INSTALLATION OF KITCHEN EXTRACTION SYSTEM AT
THE KINGS ARMS, THE GREEN, SHOULDHAM, PE33 0BY

PLANNING PERMISSION REF. NO. 22/00491/F

PLANNING APPLICATION FOR VARIATION OF PLANNING CONDITION 2

Revision Information		Drawing No and Revision		SLW177120-DRG-001-R1 APPROVAL	
Revision No	Revision Date	Revision Information			
R1	11/01/2022	First Issue

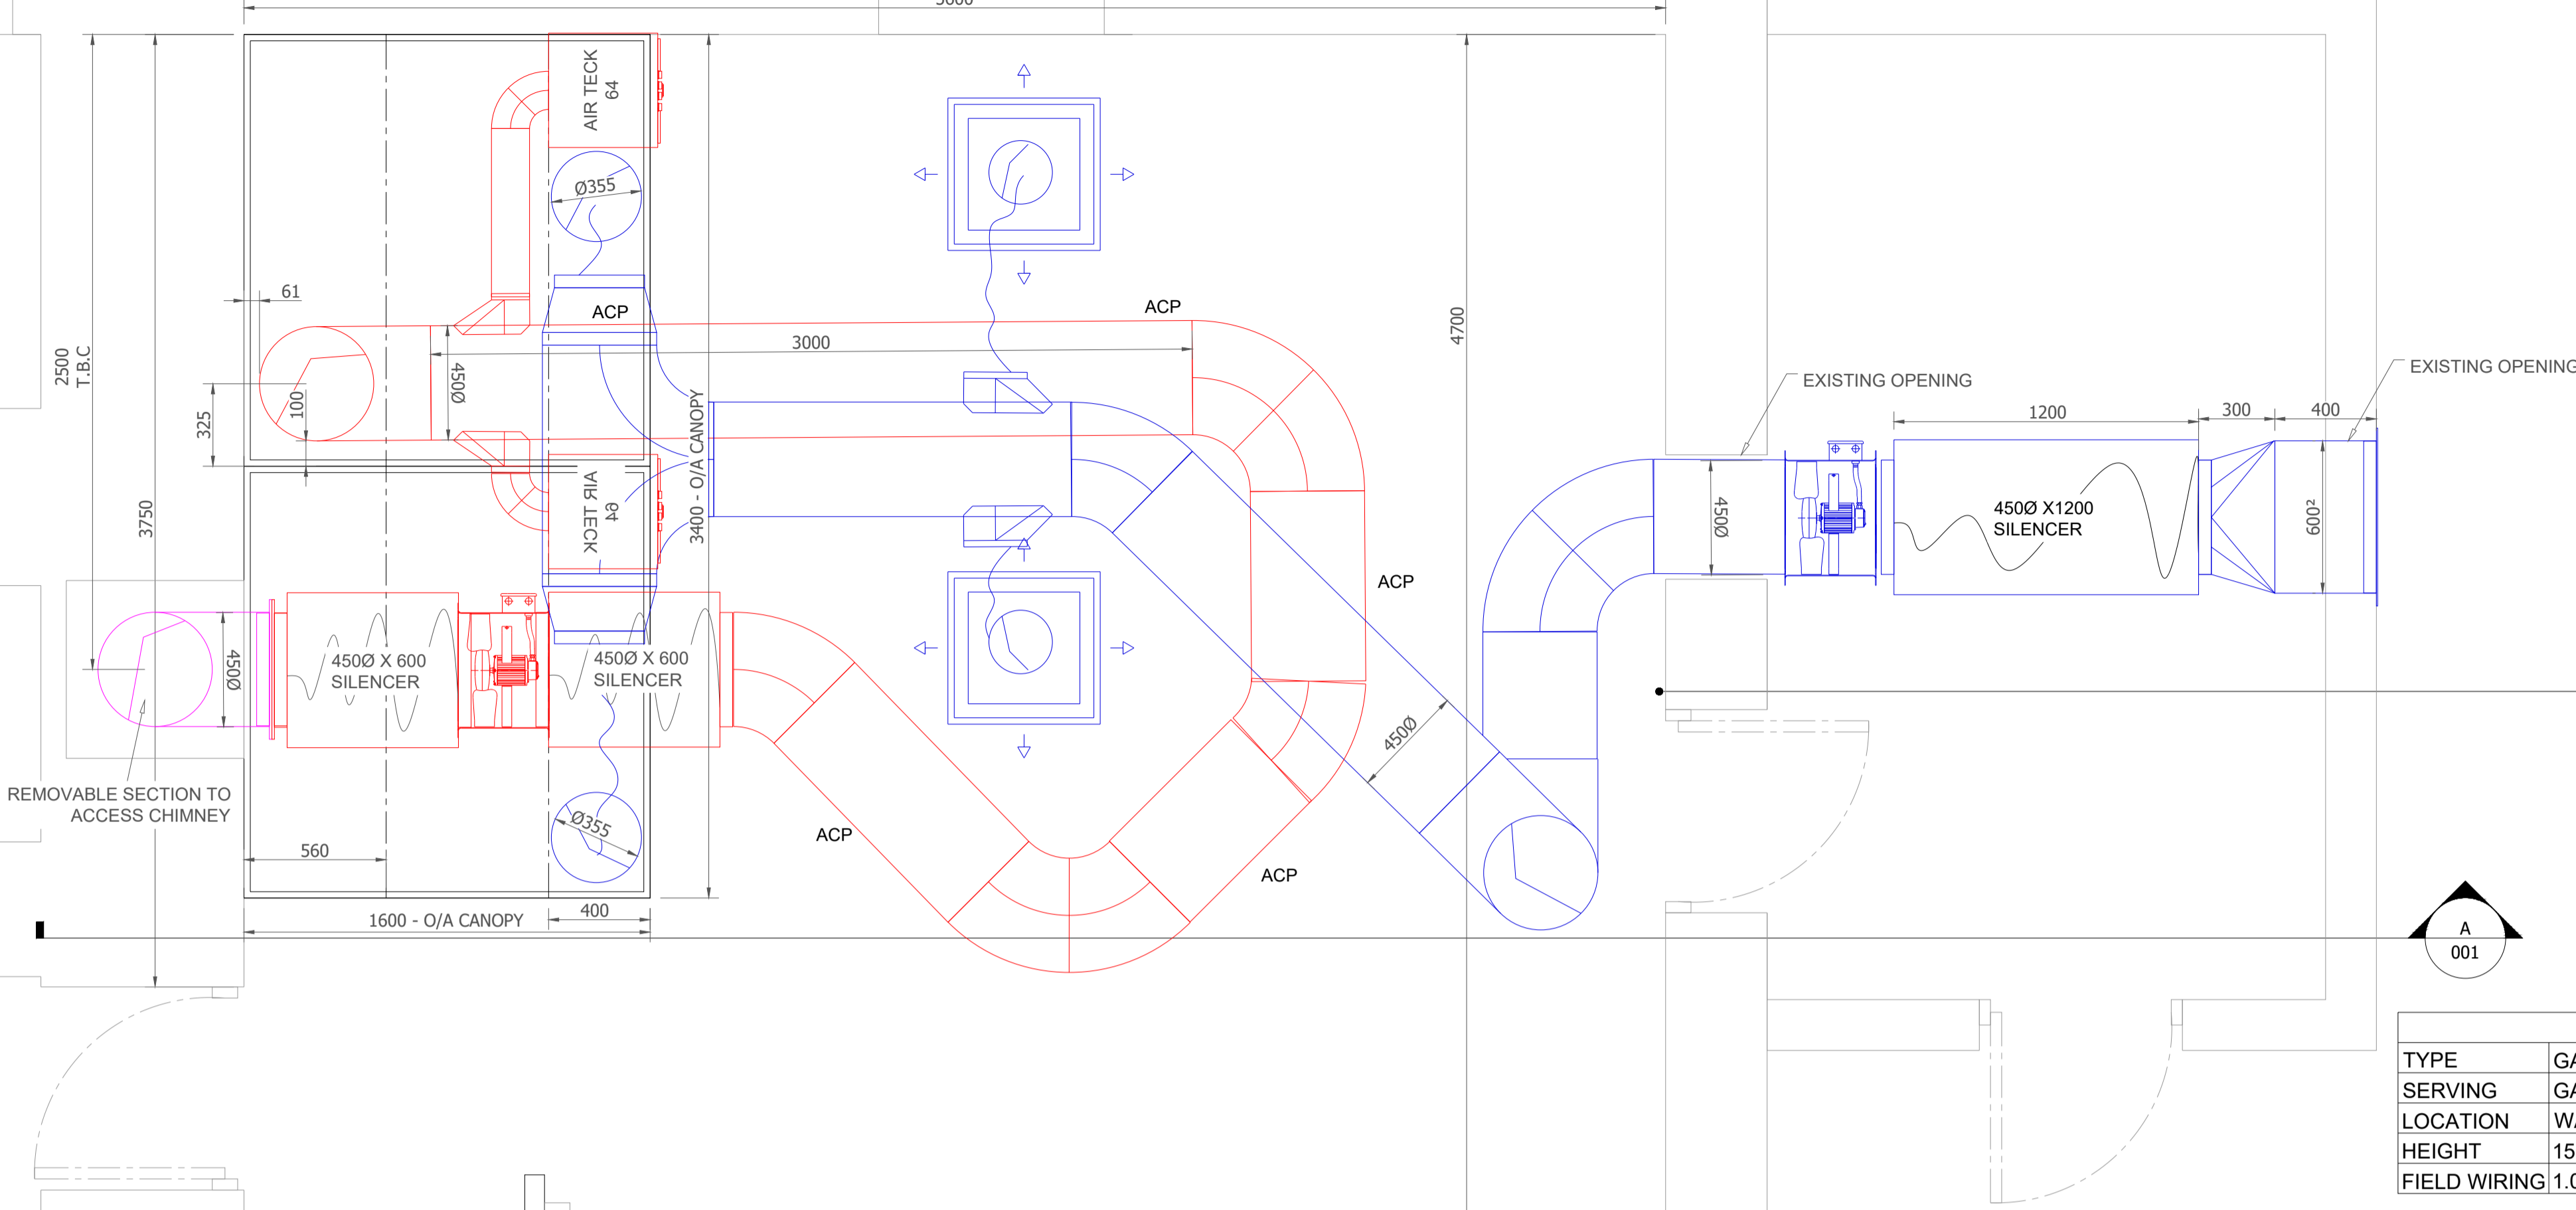
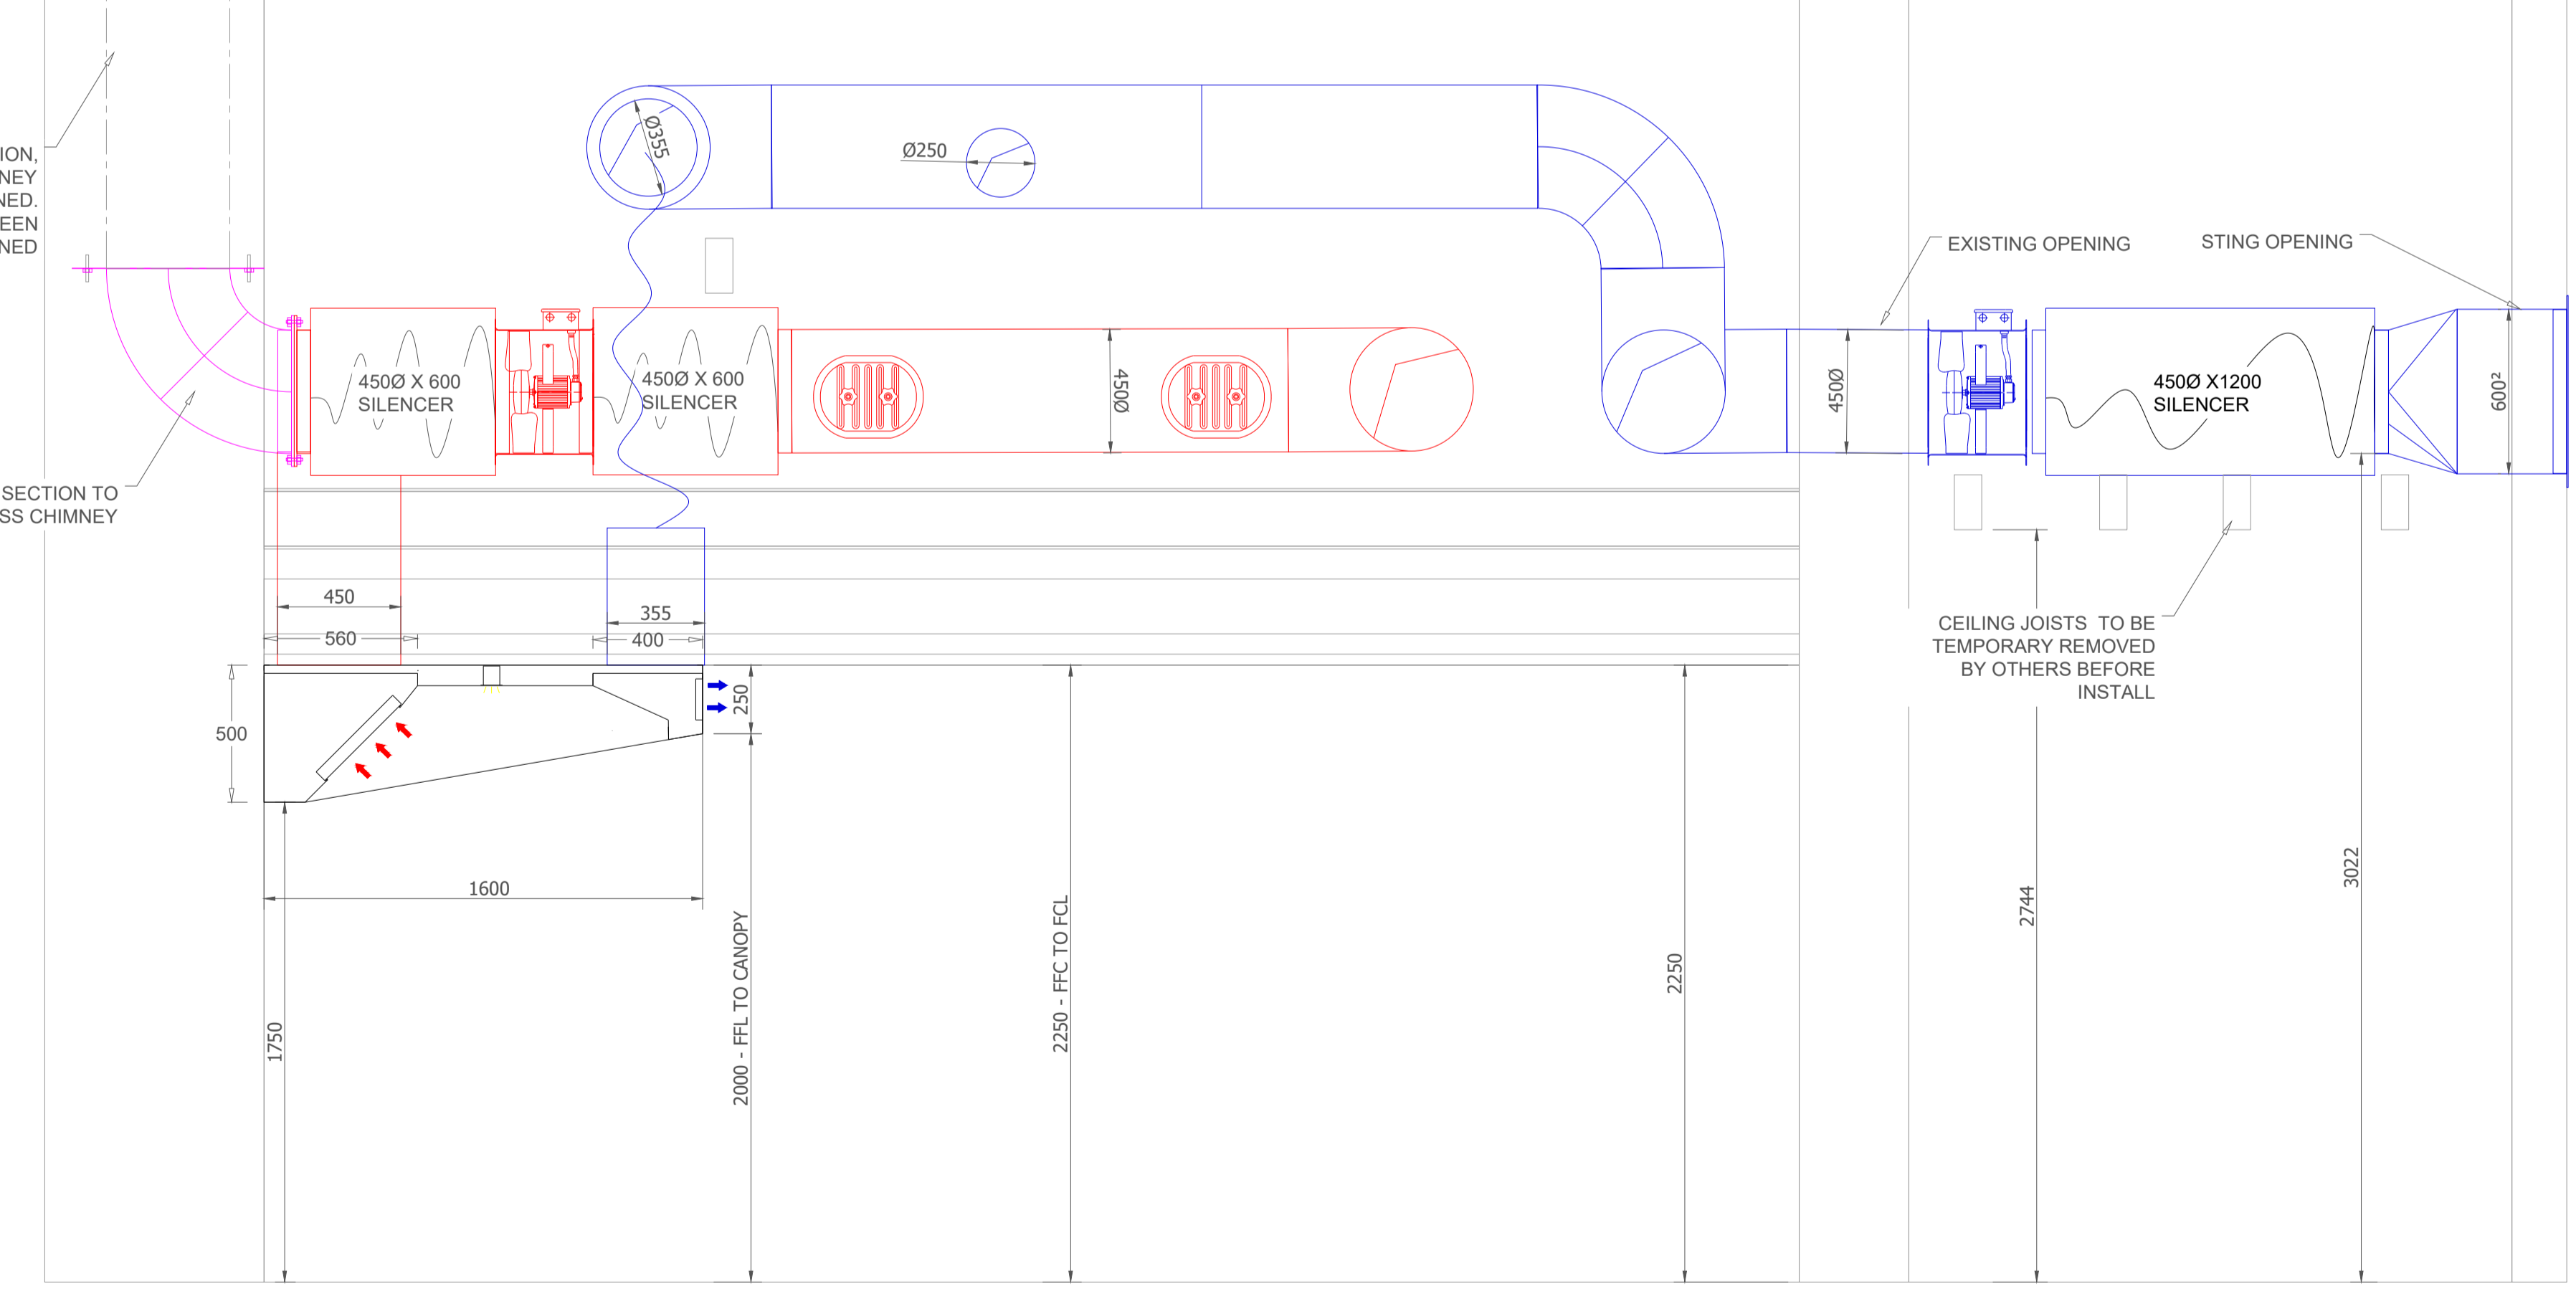
C.K.Direct have now completed their design work and specification, and as a result drawing number 1715.2 and C.K.Directs quotation/specification, both referred to in planning condition number 2 has been revised to reflect this re-design. Copies of drawing number 1715.2 - revised 12/01/2023, C.K.Directs up-dated quotation/specification together with C.K.Directs working drawing specification SWL 177120-DRG-001-R1 dated 11/01/23 are enclosed with this submitted planning application.

Up-dated specification from C.K.Direct together with approval of working drawings supplied by C.K.Direct
